## Appeal Decision

**Appeal Ref: APP/R5510/D/23/3326037**

**5 Greencroft Avenue, Ruislip HA4 9JG**

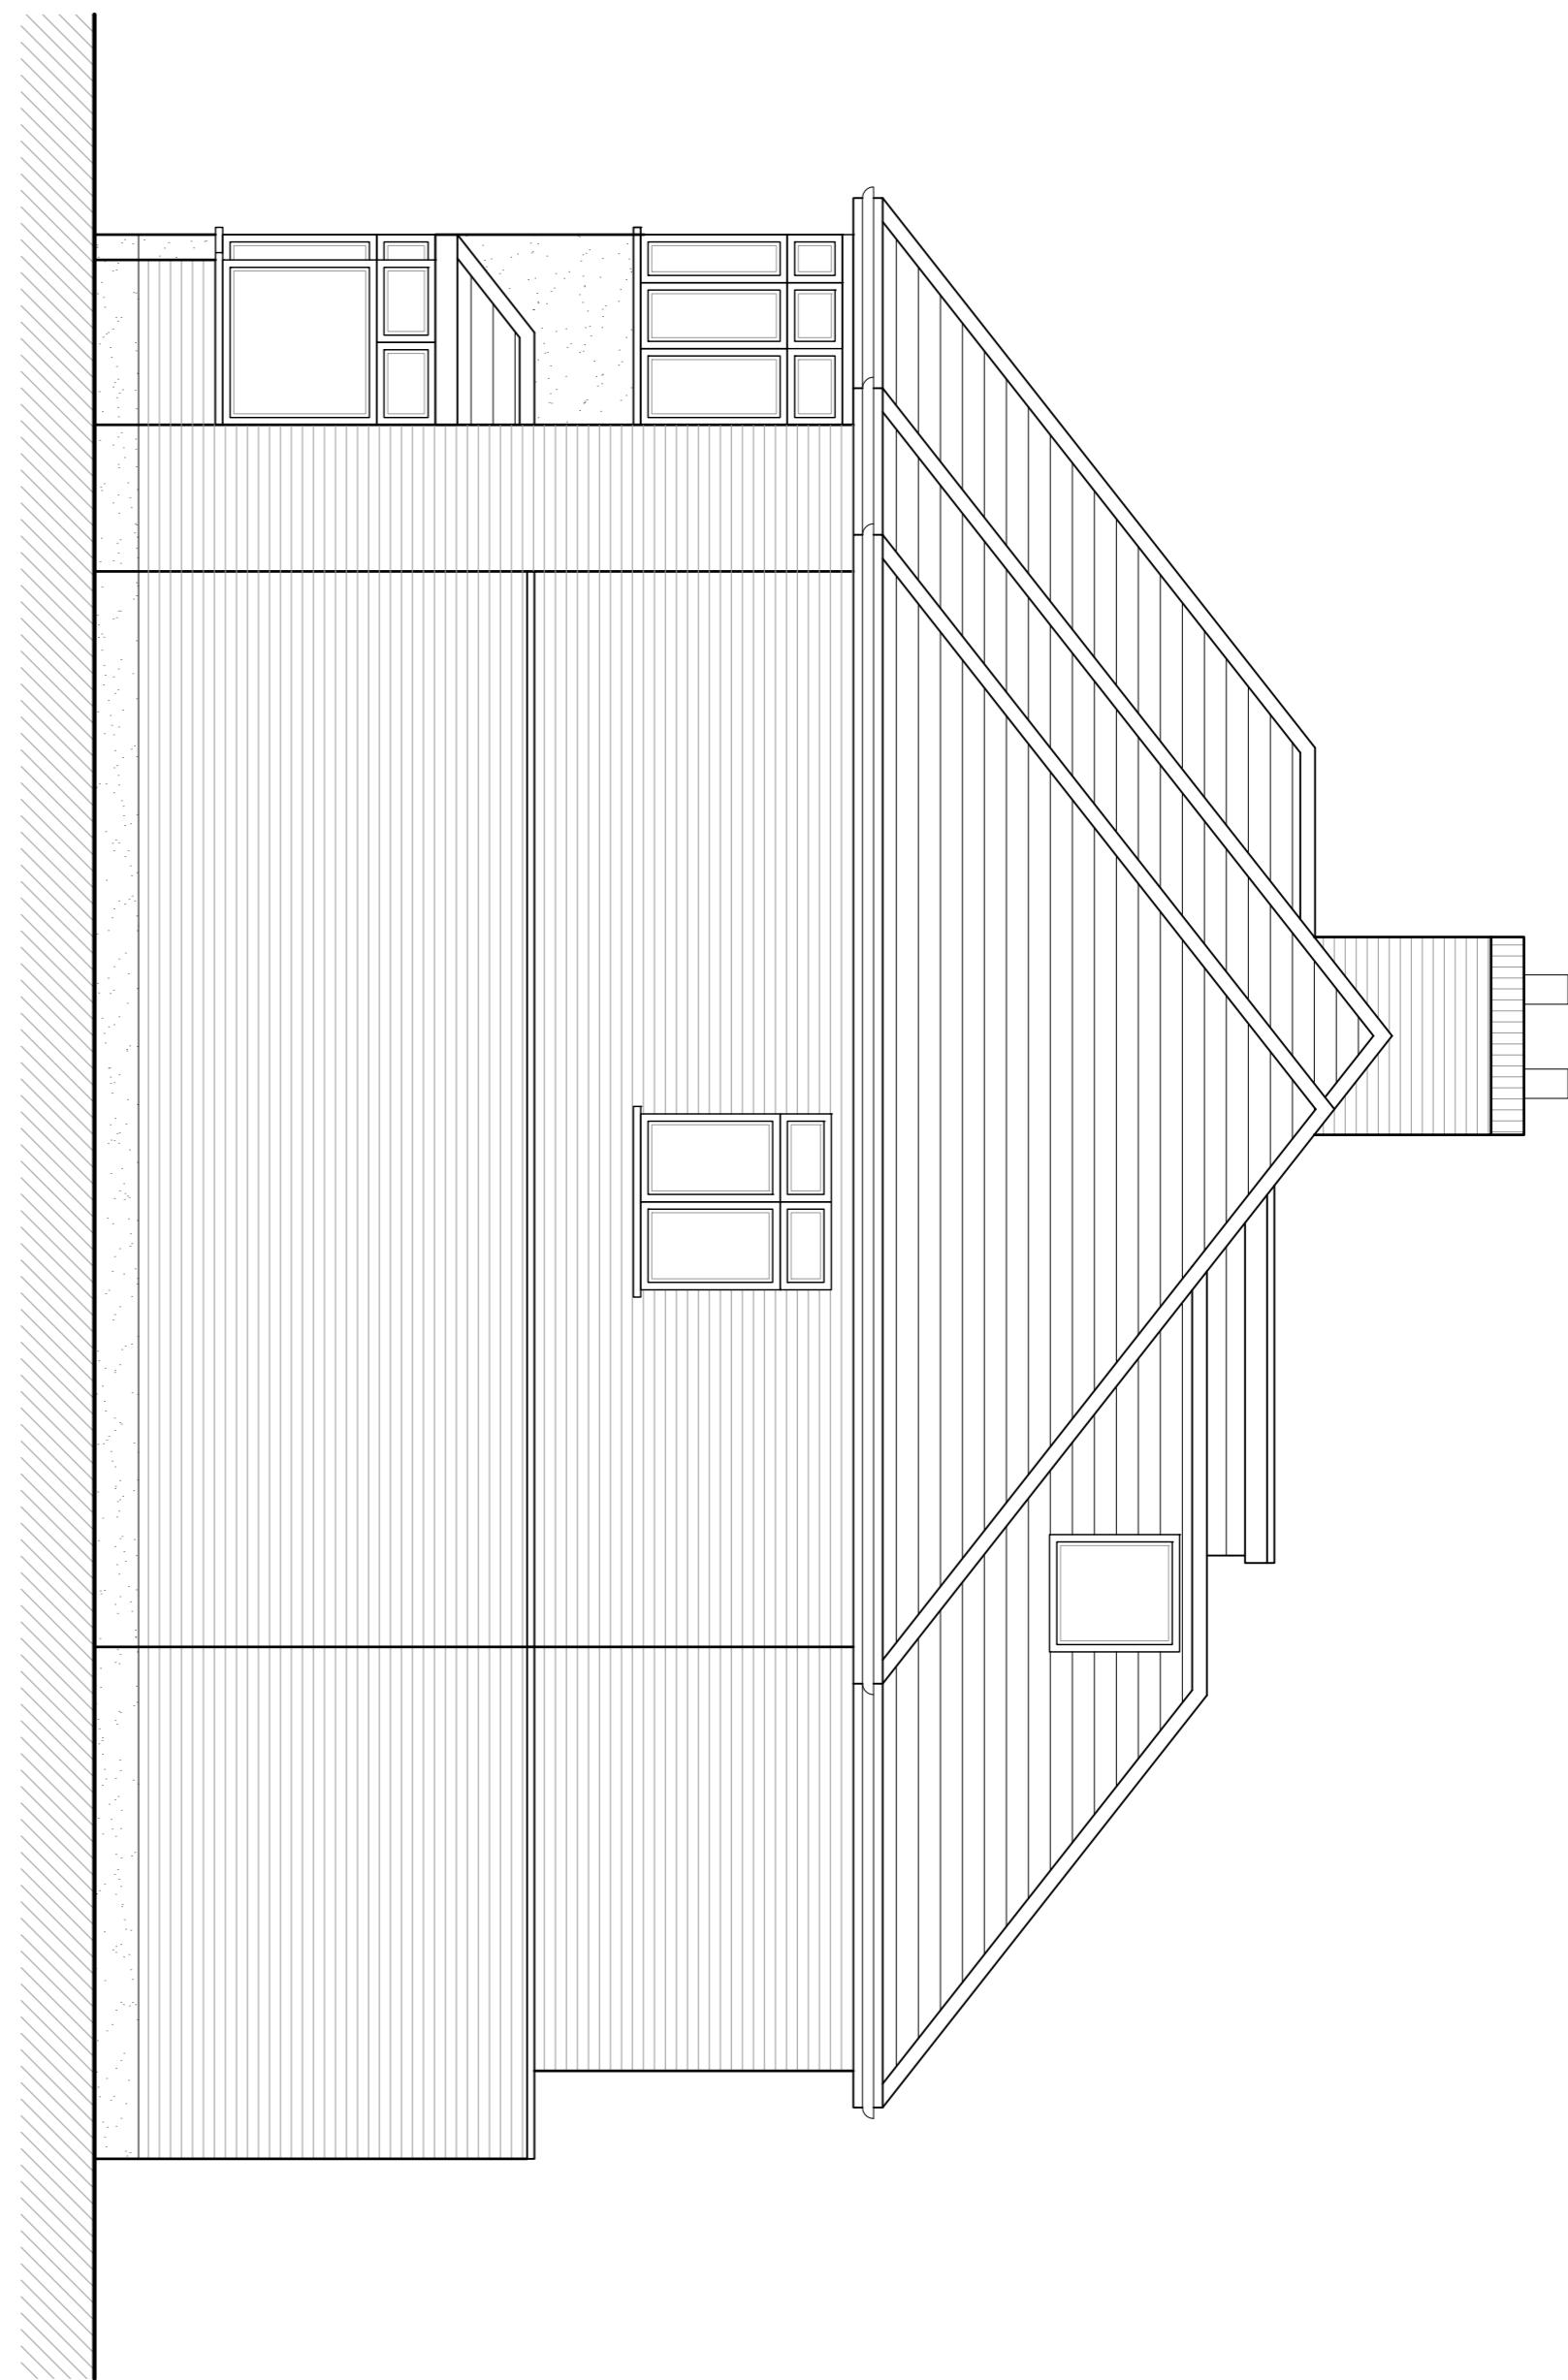
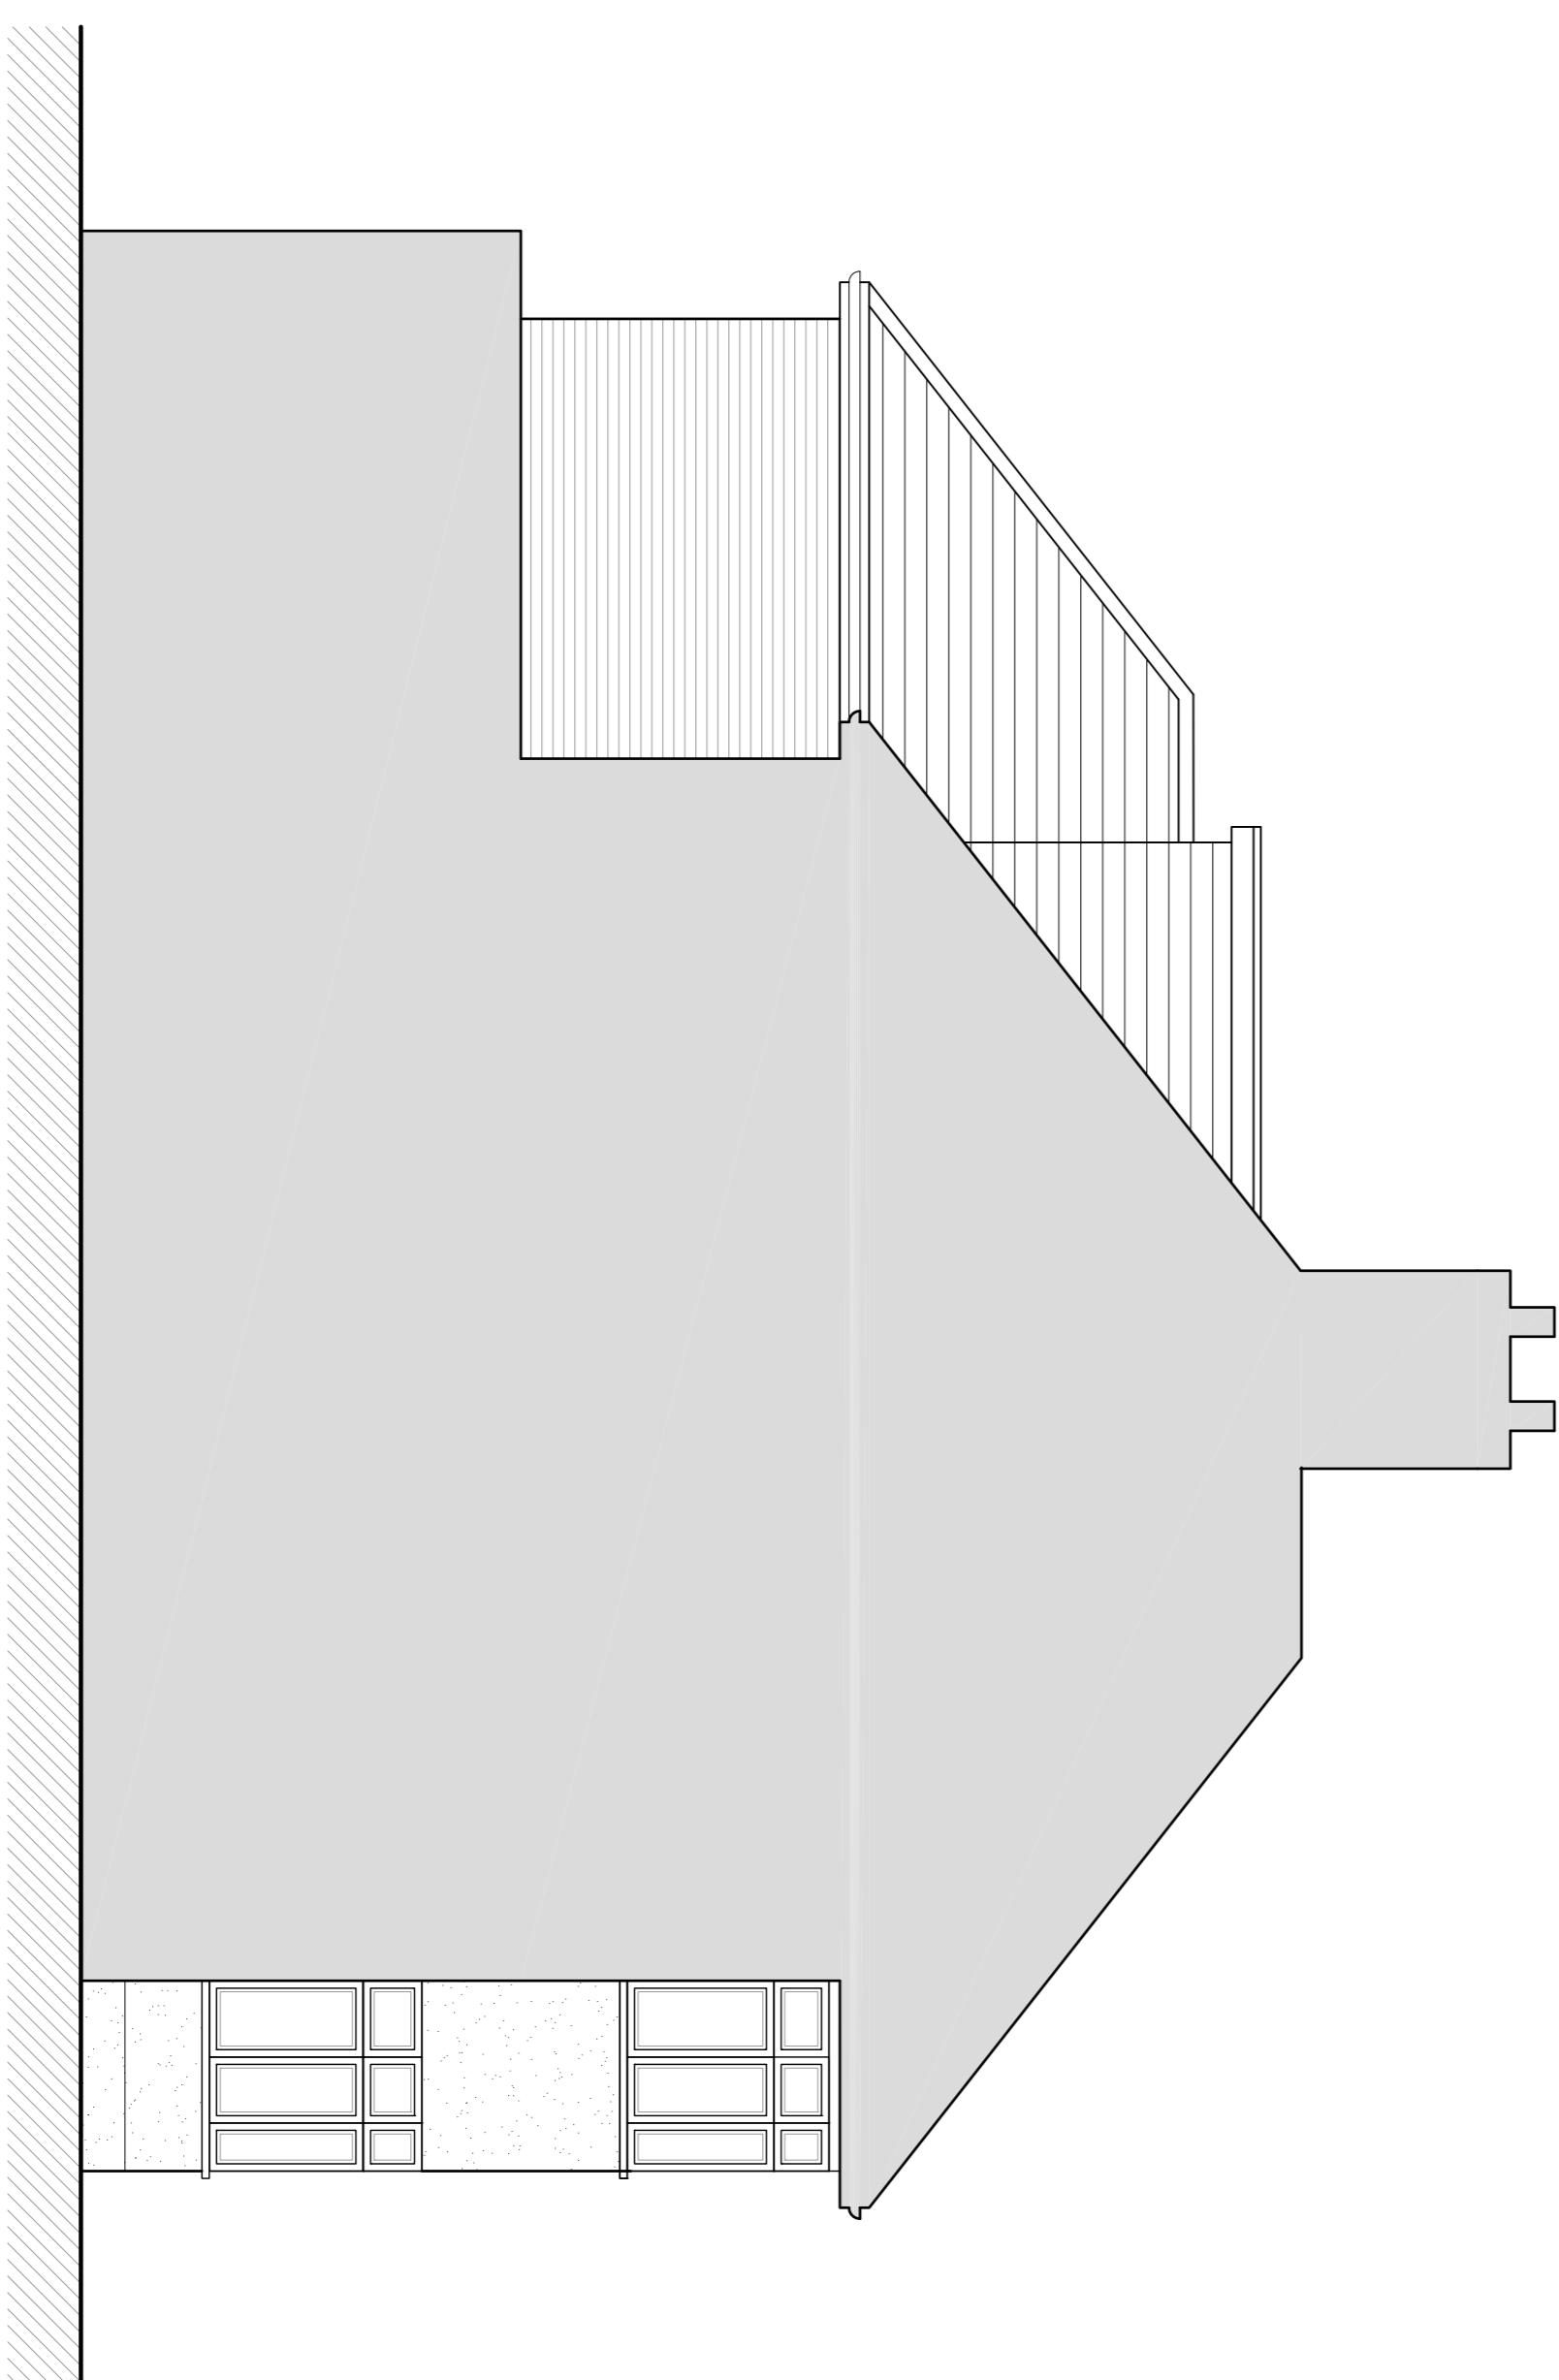
6. I consider that the width of the two storey side extension would be uncomfortably wide in relation to the width of the existing dwelling, and its over prominence would be exacerbated by the width of the roof ridge in relation to the main roof of the existing property. I have noted the set back from the front elevation as well as the set down from the ridge line, but the proposal would still appear both overly wide and dominant in relation to the scale and proportions of the existing dwelling. The Appellant has contended that the existing side car port/ store should be regarded as contributing to the width of the existing property, but it would not appear to be part of the original property; is single storey only and is lightweight in appearance compared with the over prominence of the proposed addition.

8. Because of the spacing to the adjoining pair of semi-detached properties, including No 7 Greencroft Avenue, which turns the corner into Broadhurst Gardens, the side of the appeal property is particularly visible in street scene views. The over dominance of the side extension and its complicated roof form would be very visible in these street scene views and would further detract from the character and appearance of the local area.
